Application No: P/46/22/PL
Site Address: 12 East Front Road Pagham PO21 4SU
Description of works: Demolition and erection of 1 No dwelling with detached garage, hardstanding and landscaping. This application is in CIL Zone 4 and is CIL Liable as new dwelling.

Thank you for your internet representation made on 6th May 2022 which has been recorded as no objection with the comments as follows:

I own the direct neighbouring property, 14 East Front Road. I do not object to 12 East Front Road being rebuilt, but have had to put Object in order that the following points can be taken into account.

SIDE ELEVATION

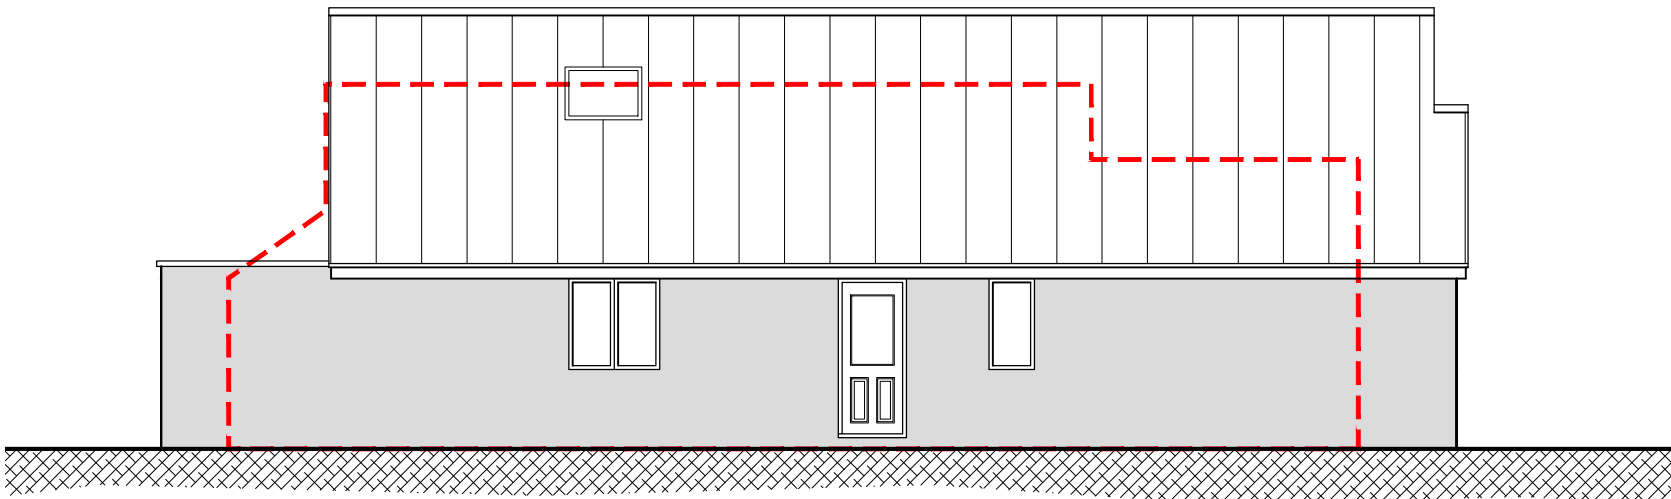
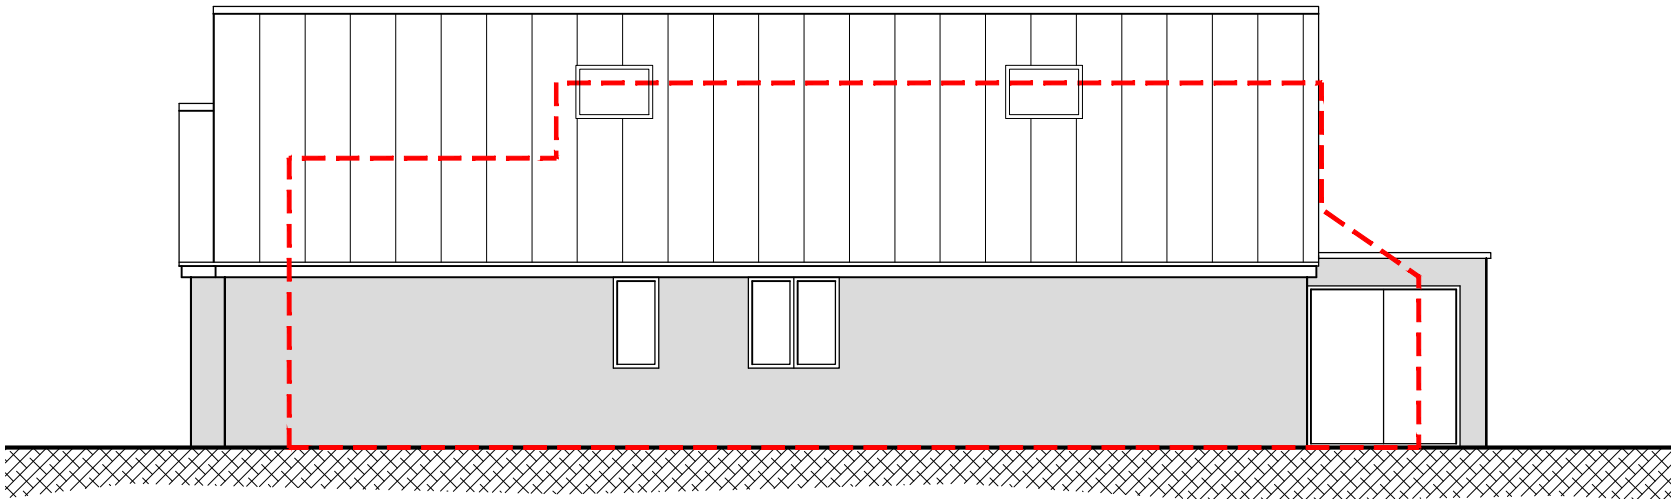
The two windows and door facing my property would be looking directly towards the bedrooms of my property, the building lines are very close as we have a path of less than 1m to that side of our property. I would ask that a 6' fence be erected to preserve bedroom privacy and prevent any opening and closing of the door at night affecting sleep. Failing this then obscured glass and a soft close door be fitted.
